From: Michael Eastham
Sent: 12 November 2018 13:52
To: Chris Barker
Cc: Sam Sykes
Subject: FW: Application A/38/18/RES - Manor Nurseries
Attachments: Manor Nureseries Surrounding OW and HD.pdf

From: Laura Gibbons
Sent: 01 November 2018 16:30
To: Michael Eastham
Subject: RE: Application A/38/18/RES - Manor Nurseries

From: Tony Cross [redacted]
Sent: 01 November 2018 09:12
To: Michael Eastham
Subject: Application A/38/18/RES - Manor Nurseries

### **Proposed Surface and Foul Water Drainage Layout**

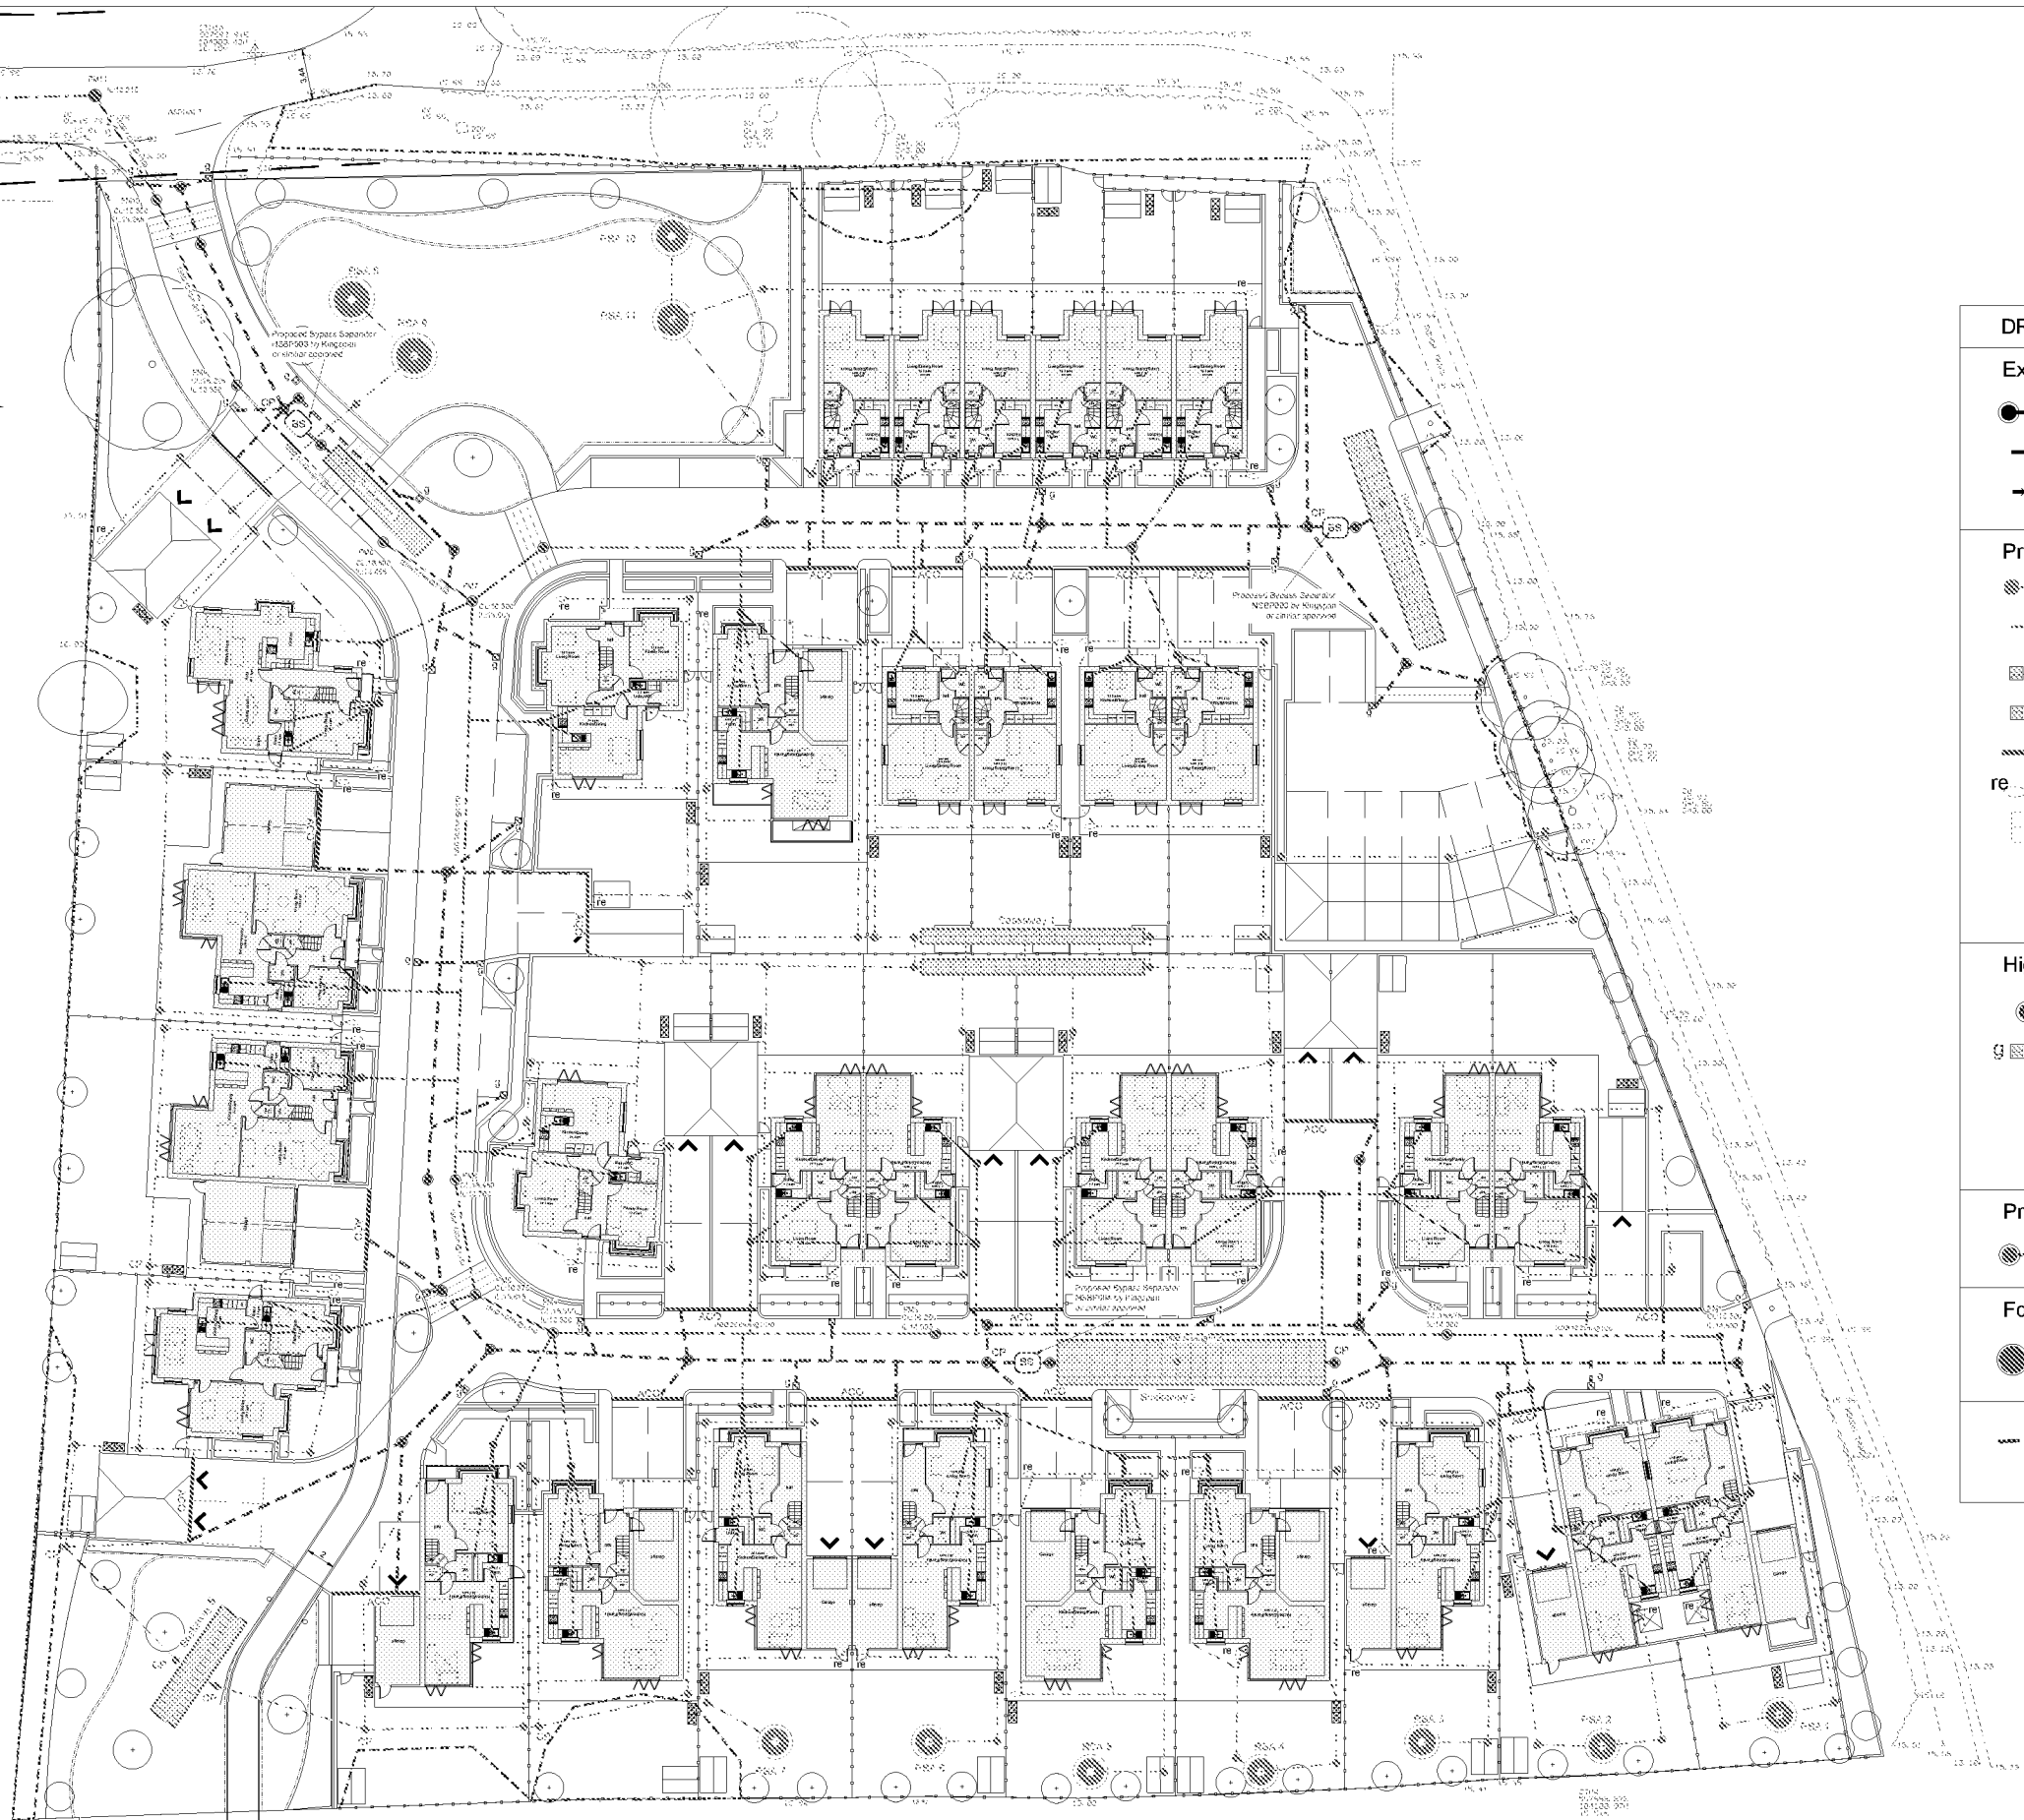
I have reviewed what Sam Sykes has stated and that is fine, it is all in line with the supplied details. They are proposing to dispose of surface water by infiltration. As I have stated previously this is all very dependent on them finding the gravel layer, otherwise the area is quite impermeable and they may need to reconsider.

Until detailed ground investigations and infiltration testing is completed it is not possible to definitively say that they will not discharge to a watercourse.

It is unclear from the Manor Nurseries plans whether they intend to discharge any surface water into this pipe and I would appreciate your clarification on this point. Should it prove to be the case, I must register my objection on this point.

Surface water runoff from roofs will be collected and channelled through a positive drainage system and discharge into the ground either via cellular crate or concrete ring soakaways.

The proposed semi detached/detached houses comprises approximately 120m³ of roof area which based on assumed infiltration rate will require 1.8mØ x 2.1m deep concrete ring soakaway for each dwelling to discharge surface water via infiltration. The proposed block of terrace houses will require two 2.1mØ x 2.1m deep concrete ring soakaways.

It is proposed the surface water runoff from the proposed driveways, parking areas and access roads will be collected via positive drainage and discharged into the ground using Cellular Crates soakaways. It is proposed that a minimum of 2 cellular crates are constructed within the sand/gravel layers to allow surface water discharge into the soils with better permeability characteristics.
